Response to Request for Further Information

*Deniliquin East BESS-SSD-
61612229*

This Response to Request for Further Information Report (**Report**) has been prepared on behalf of BESS Arctic Pty Ltd c/o Gransolar Development Australia (**the Applicant**) to address the matters raised by government agencies and Edward River Council (**Council**), during the assessment of the proposed Deniliquin East Battery Energy Storage System (**project**) development at 21356 Riverina Highway, Deniliquin (**site**).

Figure 10 Vehicle access point high-level design

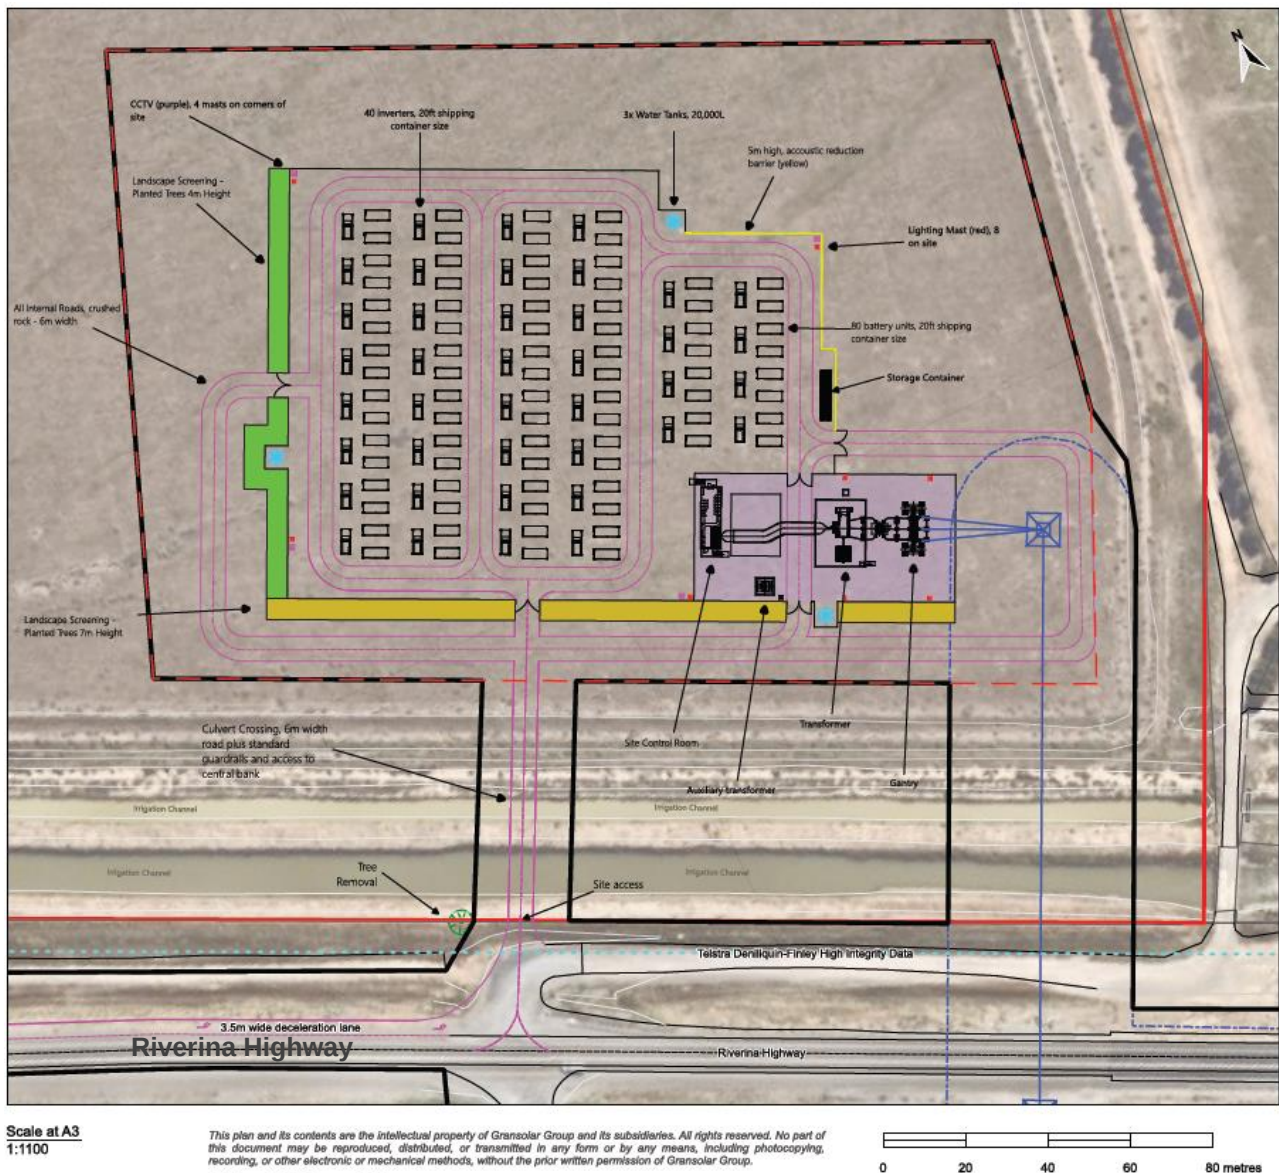
Strategic Concept Design Amendments on Site Access West – Cobb Highway	<i>The following amendments are still required to strategic concept designs:</i> <i>Site Access West – Cobb Highway</i> <i>i.</i> <i>The design proposes that the side road centre line marking is skewed and does not appear to tie into the centreline of the proposed access, nor the existing side road. Please revised in updated TIA.</i> <i>ii.</i> <i>The design proposed that the side road give way to intersection line marking (TB and TB1) is to be installed in along the shoulder of the main line. This is incorrect. The C1 line marking should extend at this offset and the TB and TB1 line marking set back behind the AUL to allow a hazard free run out area.</i> <i>iii.</i> <i>The design proposed that R2-6N no right turn signage be installed. Is this signage intended for all vehicle movements for both the development access and the existing access arrangements. Please clarify if it is intended to restrict right turn movements during construction only.</i>	Strategic Designs as requested by TfNSW have been prepared and appended to the updated TIA. <i>Note the strategic concept design has been updated for the site access intersection with the Riverina Highway.</i> <i>No site access is proposed to the Cobb Highway.</i>
